Application number: 2019/91980	
What is the application for?:	Erection of two storey side extension, front porch and formation of new vehicula
Address of the site or building:	6, Osborne Terrace, Batley, WF17 0LZ
Postcode:	WF17 5NN

BLOCK PLAN
SCALE 1:100

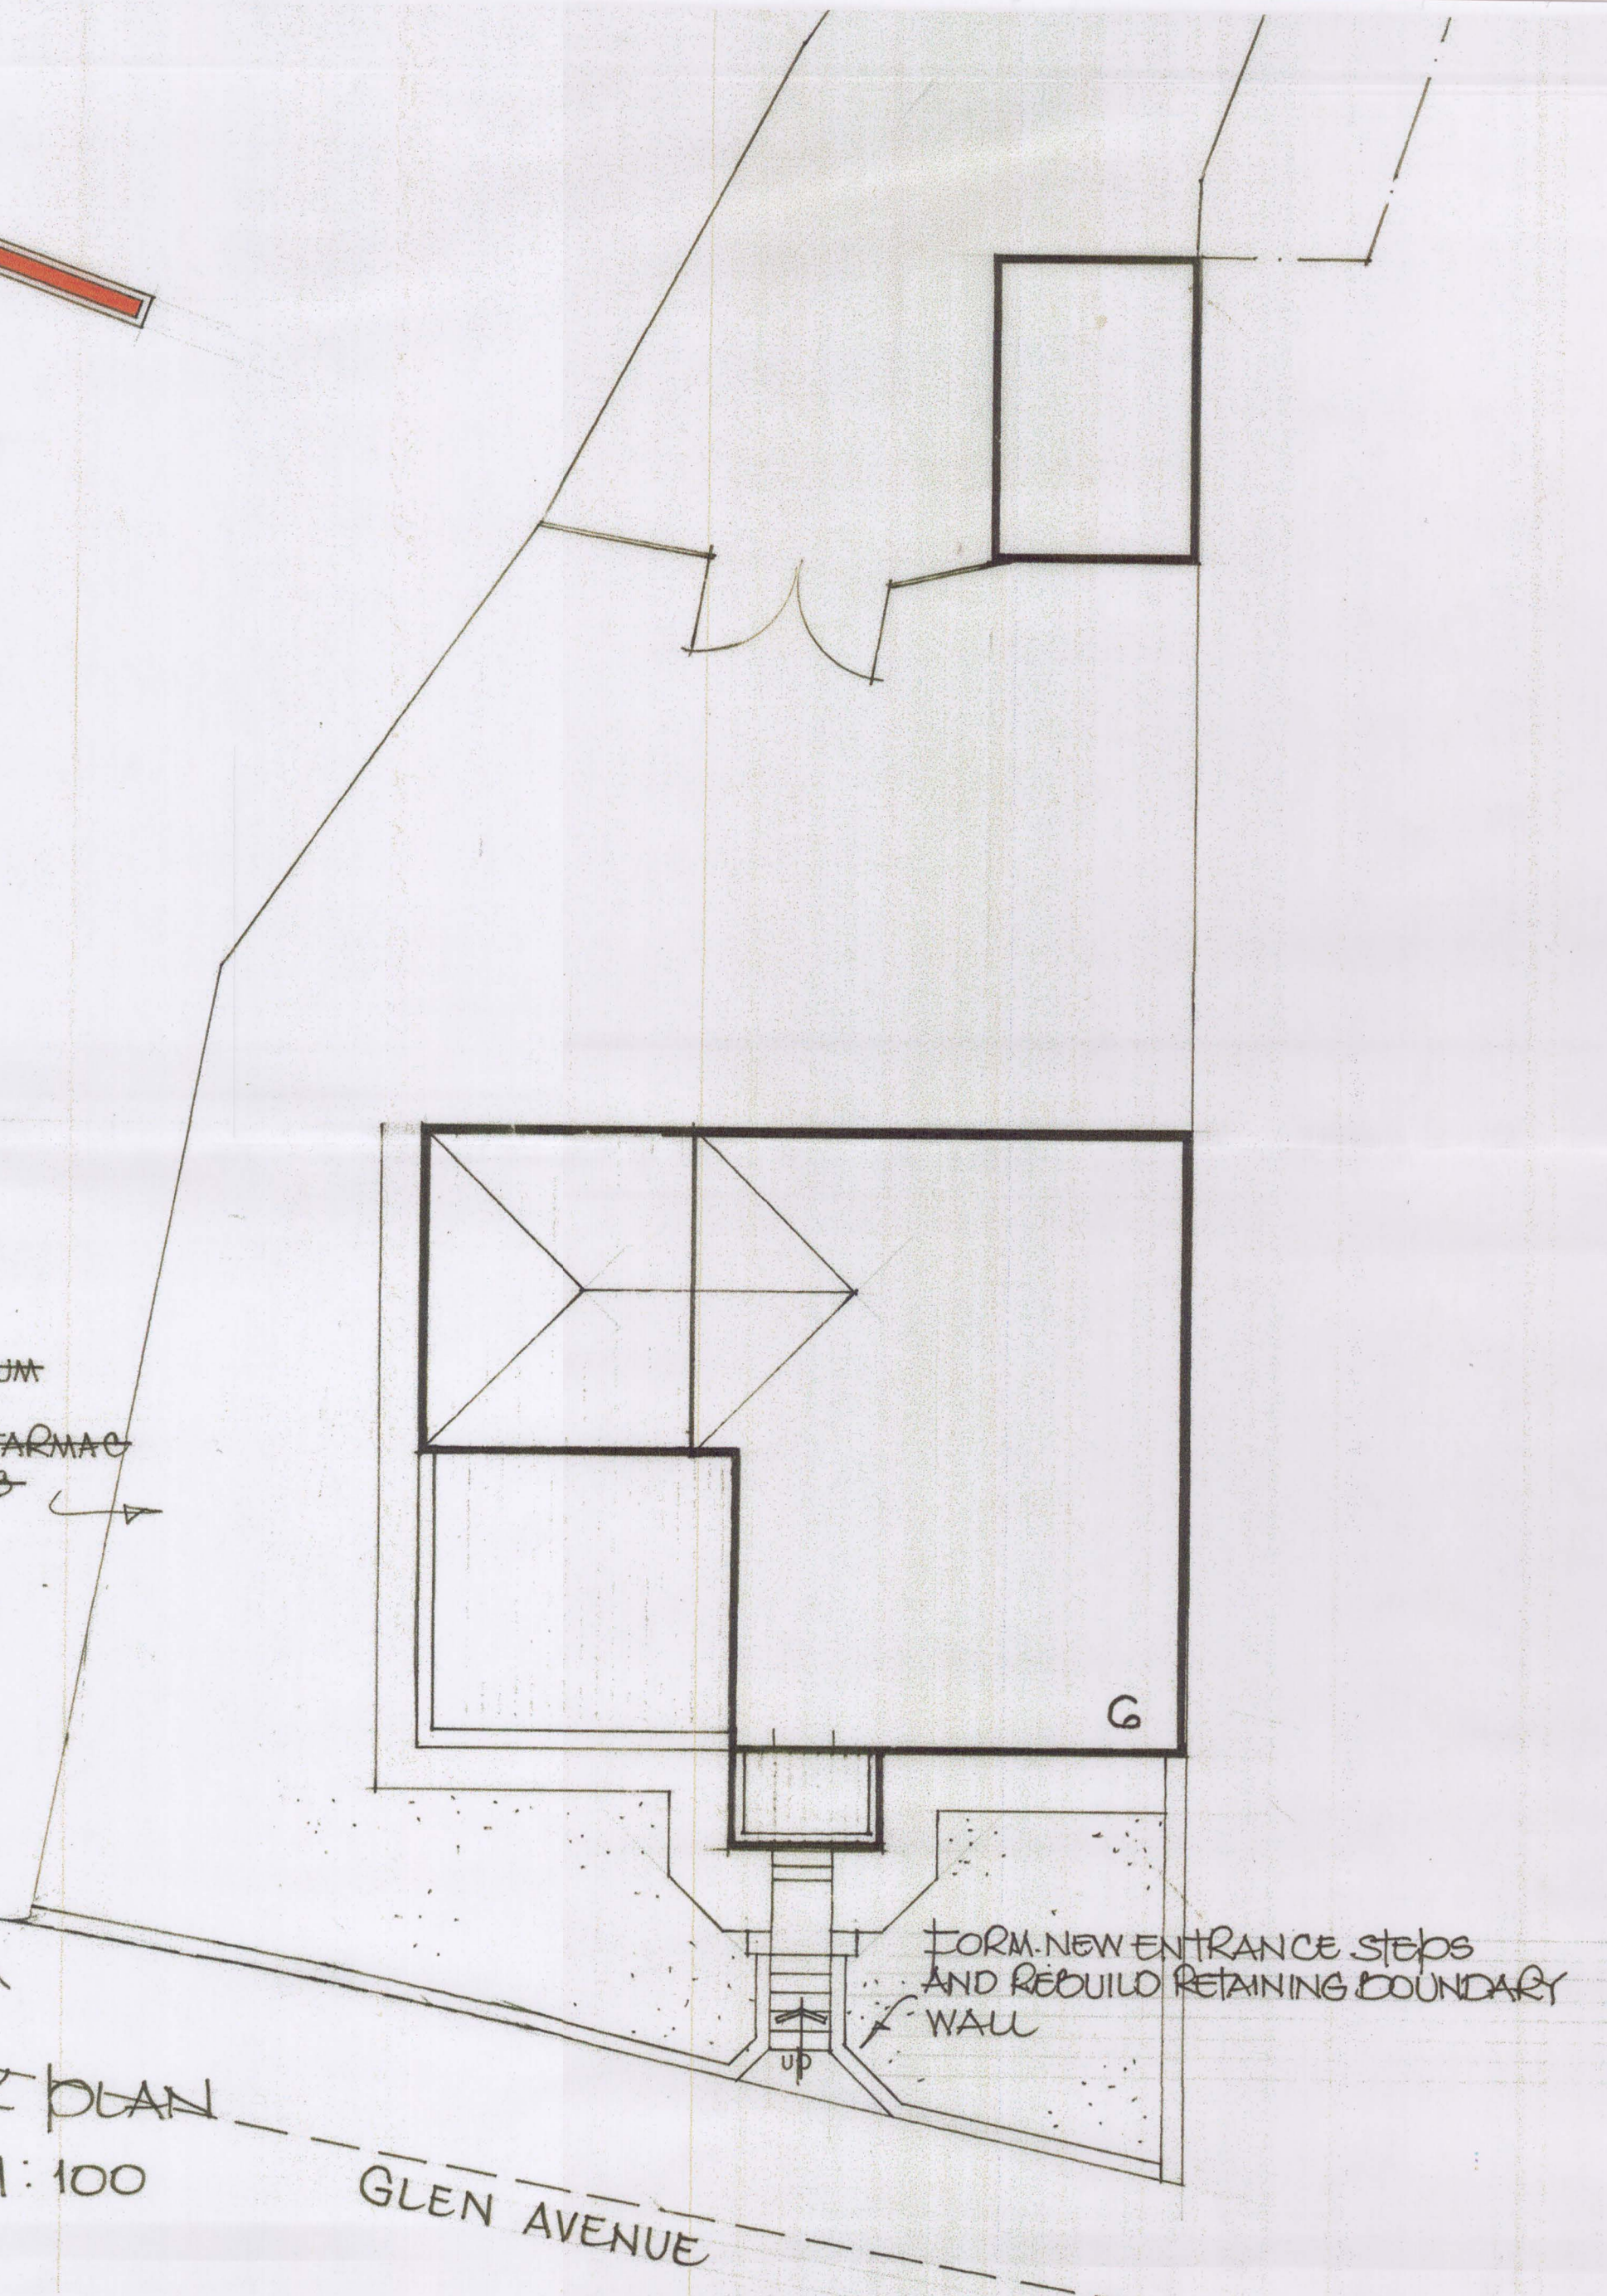
Type of comment: An objection
I wish to submit the same objection, as I have previously submitted, as the application has not changed from the previously rejected one. The objection is to the proposed vehicular access to number 6 Osborne terrace (application 2019/91980) from Wayne Close. The property has ample parking for several cars to the rear of the property (at it's own address) having purchased land from Kirklees previously. Wayne Close is already well used by residents of Wayne Close as well as being used as a 'rat run' from Grosvenor Road and York Road through to Batley Field Hill. At school pick up times Wayne Close is used by parents picking their children up from The Boys High School causing a bottle neck onto Batley Field Hill by double parking. If the plans to allow access to 6 Osborne Terrace from Wayne Close go ahead If they all have a drive onto Wayne Close there will be considerable disruption caused as well as difficulty of access for emergency services and utility services. As well as a drive to Wayne Close the plans also show a gate and footpath straight to the front door. There is already a walking access path from the end of Wayne Close to all of Osborne Terrace and a separate path will mean that visitors to Osborne Terrace will park on Wayne Close, even if they were unable to drive up to the house. I am concerned that should the plans for access be approved it will cause significant disruption and disturbance . I have no objections to any other part of the plans, . I understand that there will be short term disruption and am ok with that but I feel that the plans for access will cause long term disruption to the infrastructure and hope that you will consider this before granting planning permission.
